18 December 2020

Application Number SSD-10421
Proposal name Weigall Sports Complex, Sydney Grammar School
Address Neild Avenue, Rushcutters Bay

Woollahra Council staff have reviewed the information and is generally supportive of the proposal, subject to the following recommendations:

1 EAST ELEVATION

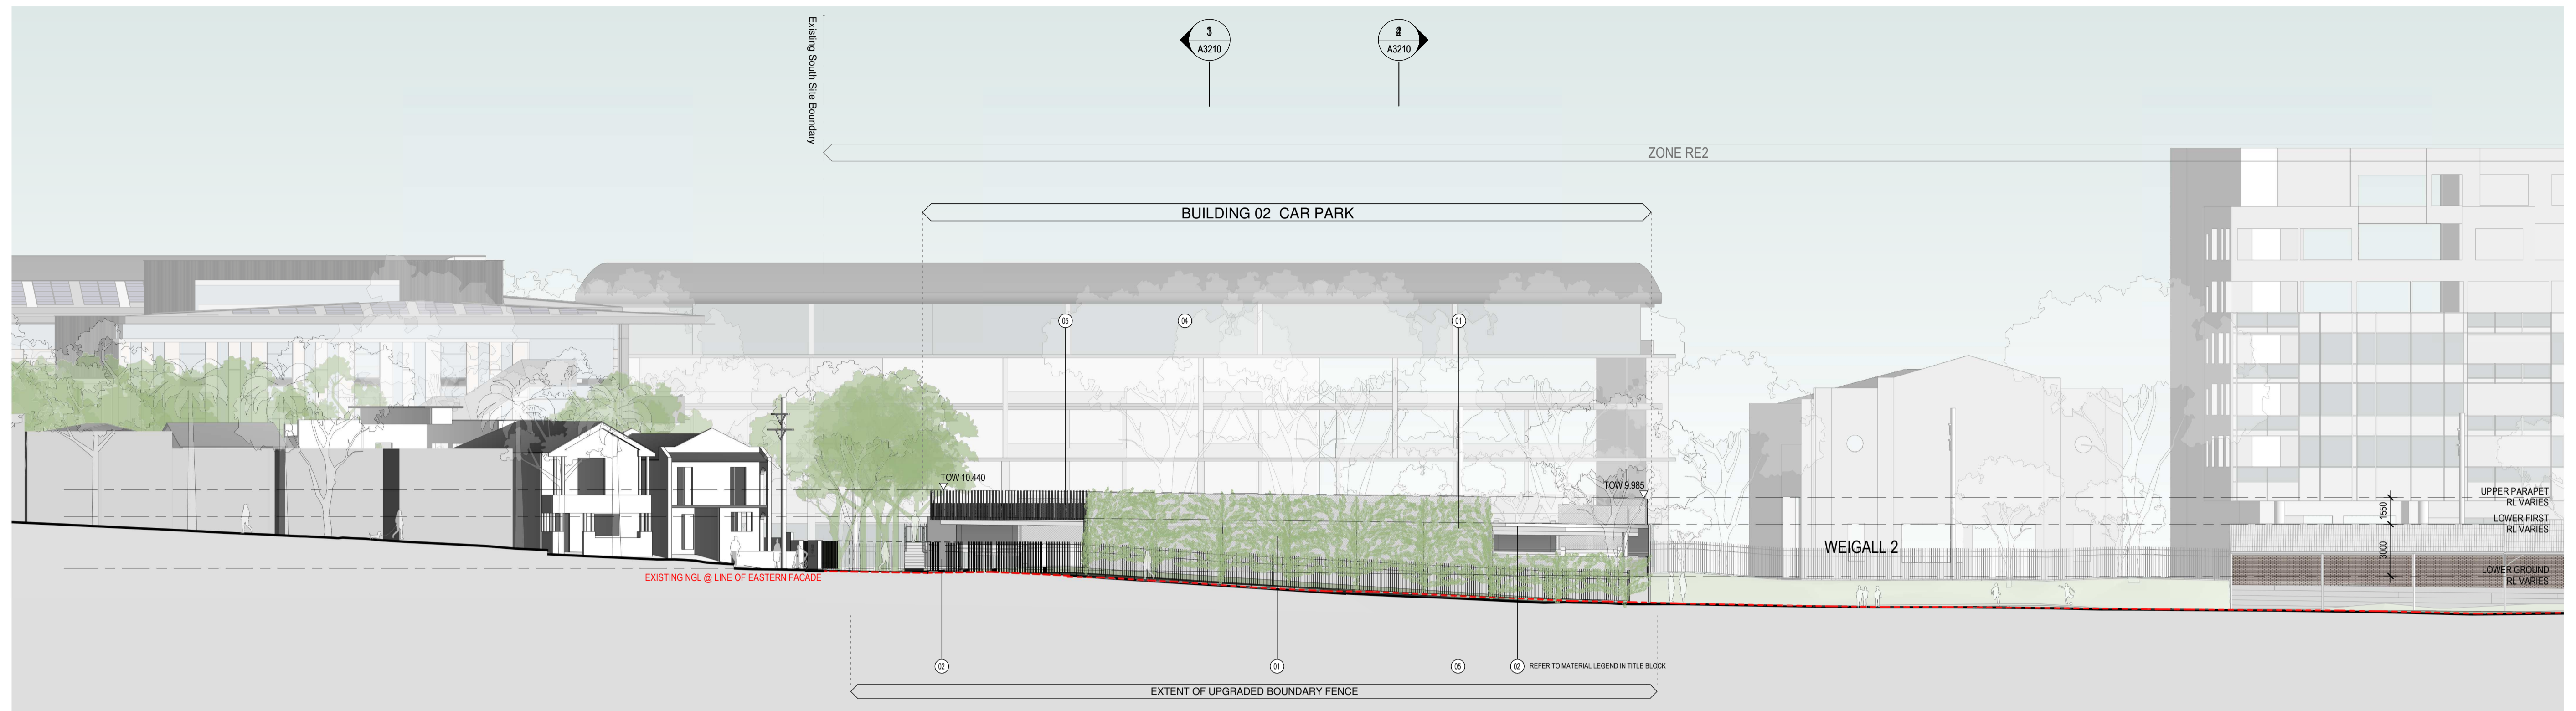
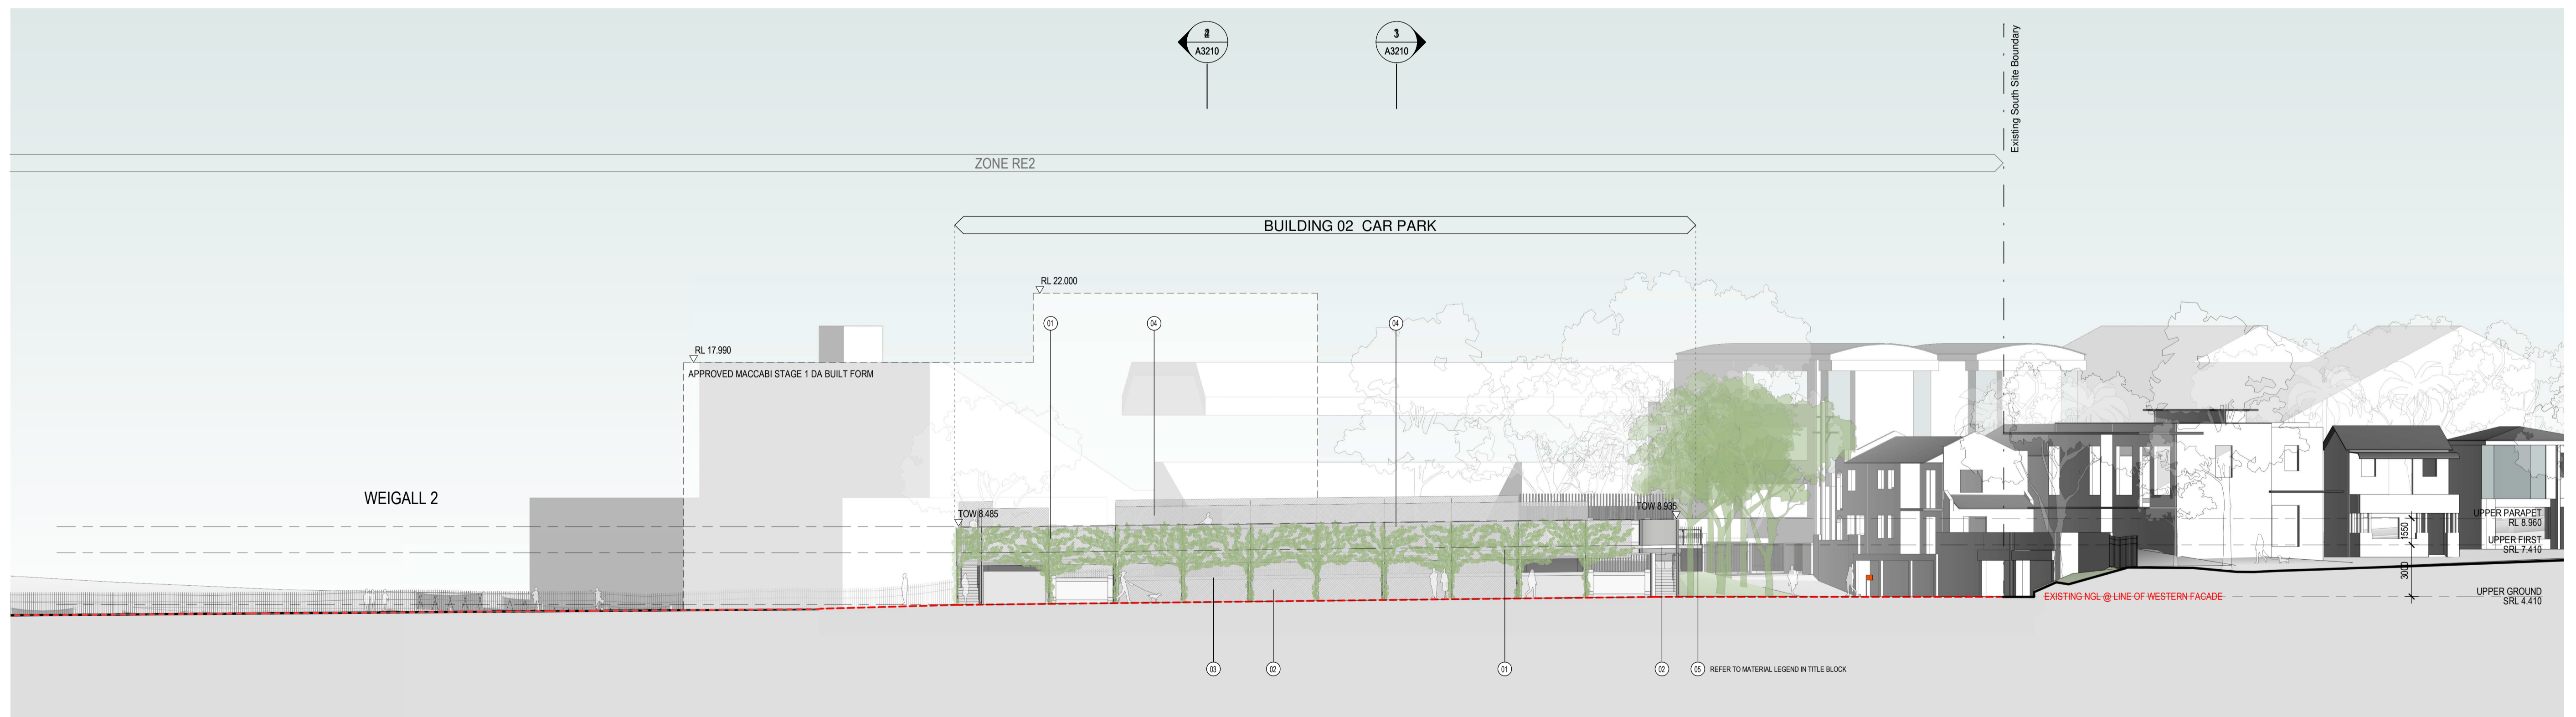
Minimum openings/windows are proposed at the interface with Neild Ave (on the western façade) and Vialoux Ave (on the eastern façade). This is not an acceptable outcome from an urban design point of view in terms of streetscape character and activation of the adjoining public domain. This is inconsistent with the following provisions:

To achieve design excellence, it is recommended that the façade is amended to provide transparent openings/windows and greater articulation of the façade. One way to achieve this is through a varied material palette of high-quality finishes and materials. A denser landscape and tree canopy would further mitigate the impacts of the deactivated part of the façade on the streetscape.
